Our ref: NO/2013/104892/01-L01
Your ref: 3/2013/0137

Date: 11 March 2013

A RESIDENTIAL MIXED USE DEVELOPMENT COMPRISING UP TO 260 DWELLINGS (C3); A PRIMARY SCHOOL (D1); A NEW VEHICULAR LINK BETWEEN CLITHEROE ROAD AND THE A671 INCLUDING CREATION OF A NEW JUNCTION BOTH ONTO THE A671 AND CLITHEROE ROAD; CAR PARKING; OPEN SPACE; AND ASSOCIATED LANDSCAPING LAND TO THE EAST OF CLITHEROE ROAD (LAWSONSTEADS), WHALLEY

Site: Illustrative Masterplan

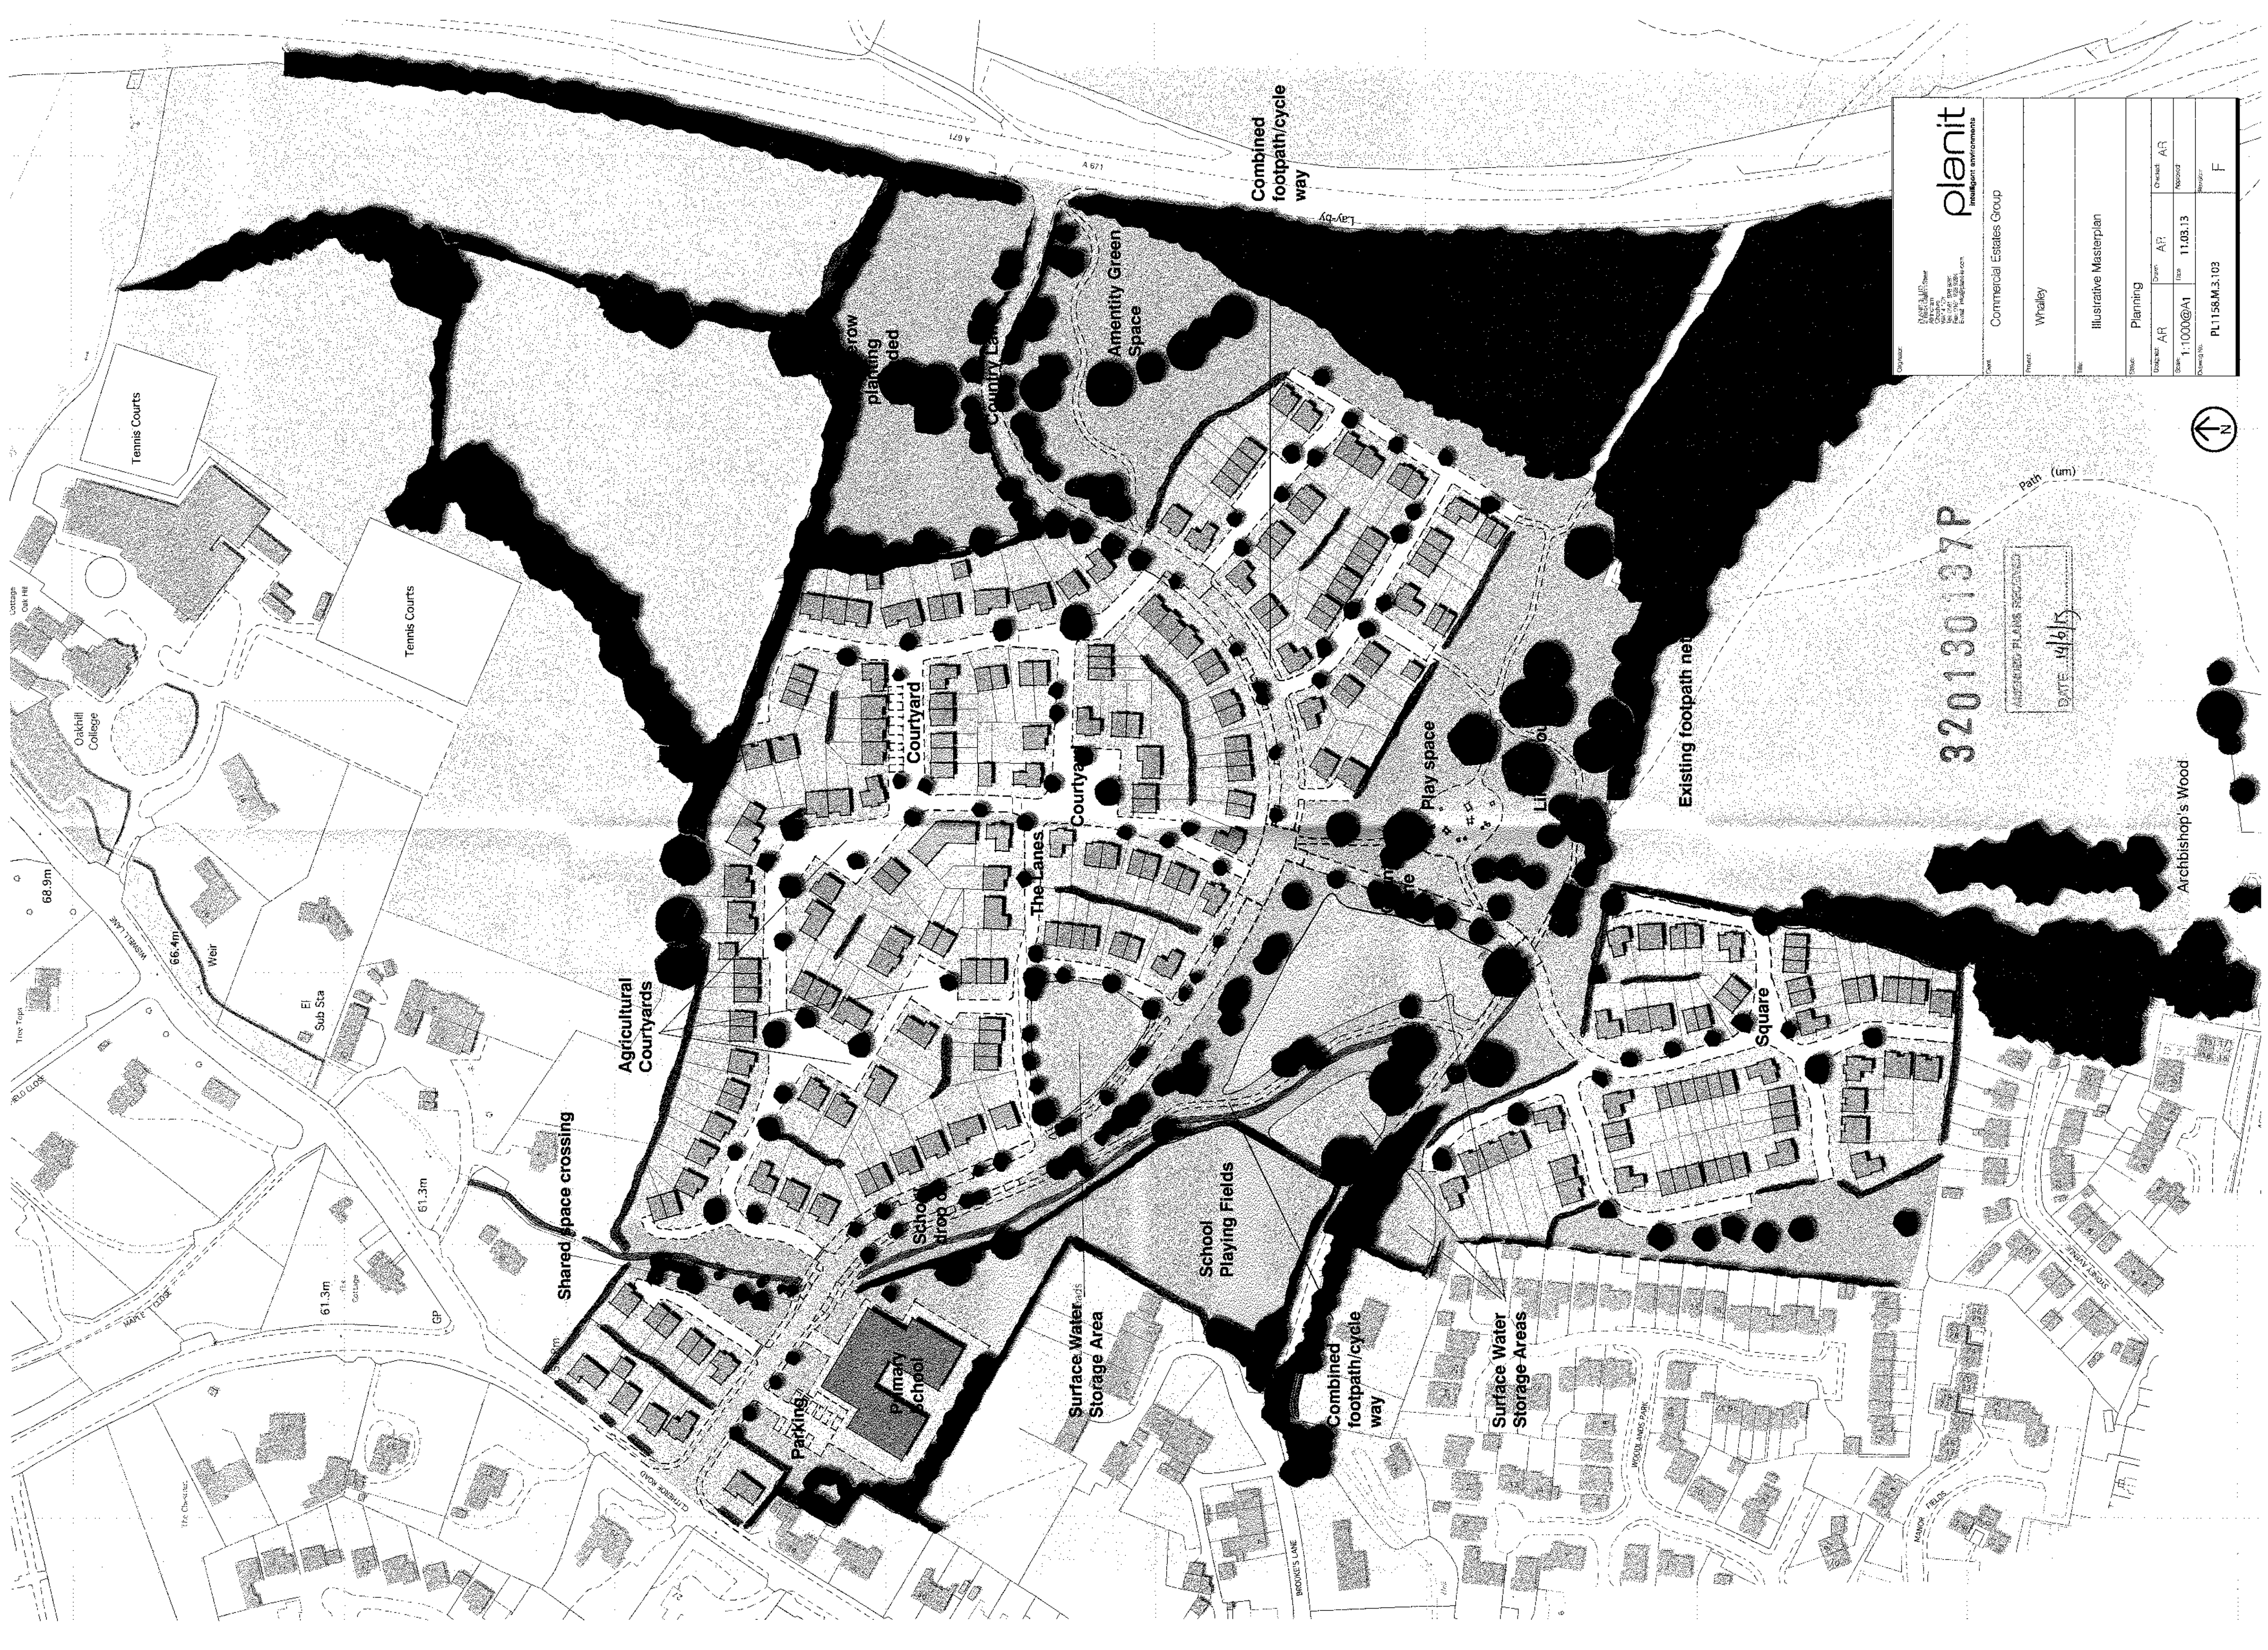
It is noted that the internal highway arrangements suggested on the illustrative layout show the proposed access road in close proximity to a watercourse. A minimum buffer between the road and the watercourse should be retained to ensure the watercourse is retained as an effective wildlife corridor and avoid any need for future modifications or works to the watercourse associated with the highway, such as retaining walls or structures.

CONDITION As part of the Reserved Matters proposal, a scheme for the provision and management of a buffer zone alongside the watercourses on site shall be submitted to and agreed in writing by the local planning authority. Thereafter the development shall be carried out in accordance with the approved scheme and any subsequent amendments shall be agreed in writing with the local planning authority.

REASON To protect ecological, recreation and amenity interests by providing a buffer between the development and the watercourse

The scheme for the buffer zones around the watercourses shall include the following:-

- Plans showing the extent and layout of the buffer zone
- Details of any planting scheme
- Details demonstrating how the buffer zone will be protected during development and managed/maintained over the longer term
- Details of any footpaths, fencing, lighting etc.
